Application Reference: 2025/1010

Site Address: 242 Darton Lane, Mapplewell, Barnsley, S75 6AJ

Introduction: This application seeks full planning permission for a Single storey side extension to dwelling.

Drawing Title.
PLAN, ELEVATIONS & SITE PLANS AS PROPOSED

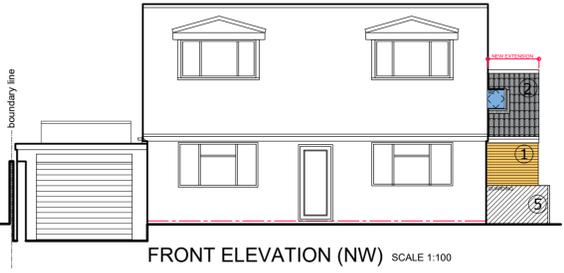
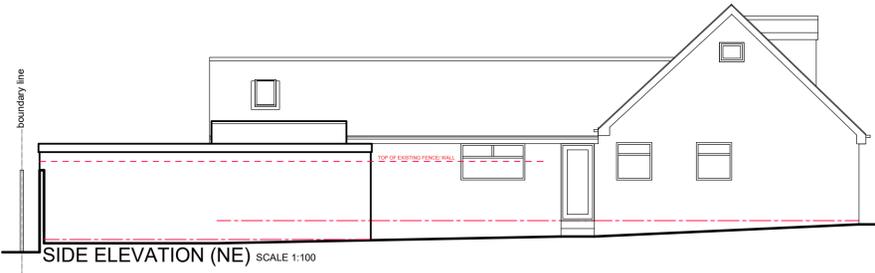
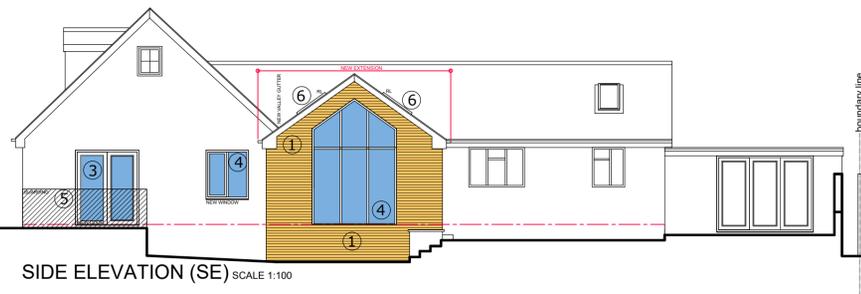
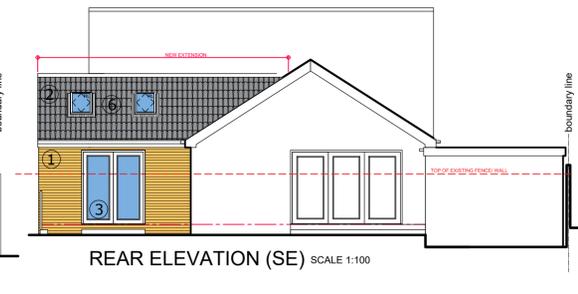
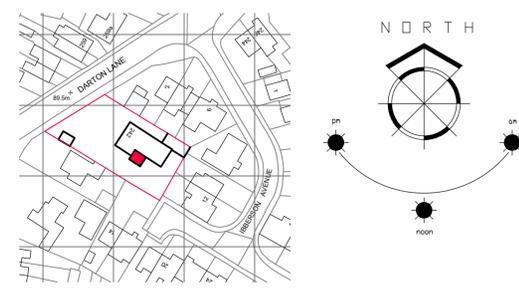
The proposed extension replaces and extends an existing extension on the south eastern, ground floor elevation of the dwelling. The footprint of the extension is only extended by approximately 8 sqm, on to an existing area of essentially raised patio. Whilst the extended footprint is modest, in contrast, the proposed gable style roof increases the height of the extension with a ridge height approximately 1.6m higher than the original flat roof. However, the eaves height remain broadly in line with the existing eaves, and the ridge height remains lower than the dwelling's principal roof.

With a heightened but more aesthetically pleasing roof, matching the existing side gable and complimenting the dwelling's main roof, any concern over the scale is outweighed by the overall improvement of the updated side extension. With the somewhat unusual layout of the streets surround the dwelling, the extension would be in quite prominent in public view from Ibberson Avenue but have a hidden or diffused view from within the street scene of Darton Lane.

Material wise, the extension would be constructed of matching brickworks, concrete roof tiles and matching white UPVC windows and doors, which also feature within the existing south eastern elevation. The guard rail (balustrade) would be made of glass.

The limited footprint size increase of the proposal may pose an insignificant impact on amenity of neighbouring dwellings No 14 and 16 Ibberson Avenue, and 240 Darton Lane. The increased height and style of the extension's roof may also have an impact on the same neighbouring dwellings but the extension would not be significantly overbearing nor should it have any measurable impact upon light levels, especially given the 6.4m midpoint distance between the extension and the south eastern side boundary, and almost double this at almost 12m to the rear boundary.

extension are located at ground floor level but would potentially overlook the first floor windows of No 10 and 12, which is a continuation of the existing impact, especially with the extension not being constructed any closer to the rear boundary and quantity of glazing in the rear elevation equal or less than is currently installed.

In relation to potential overshadowing of No 240 Darton Lane and No14 and No16 Ibberson avenue, the potential is greater with a much larger glazed window frame being installed but for all three neighbours, the impact would be on their gardens rather than direct overlooking of windows and with the 10m rule not applying to ground floor windows, any overshadowing would be diffused by existing boundary treatments with the option for neighbours to install stronger boundary treatments if desired. Specifically for No14 and No16, it would be their relatively large front gardens which may be overlooked, which unlike rear gardens are not generally considered as protected, private spaces.
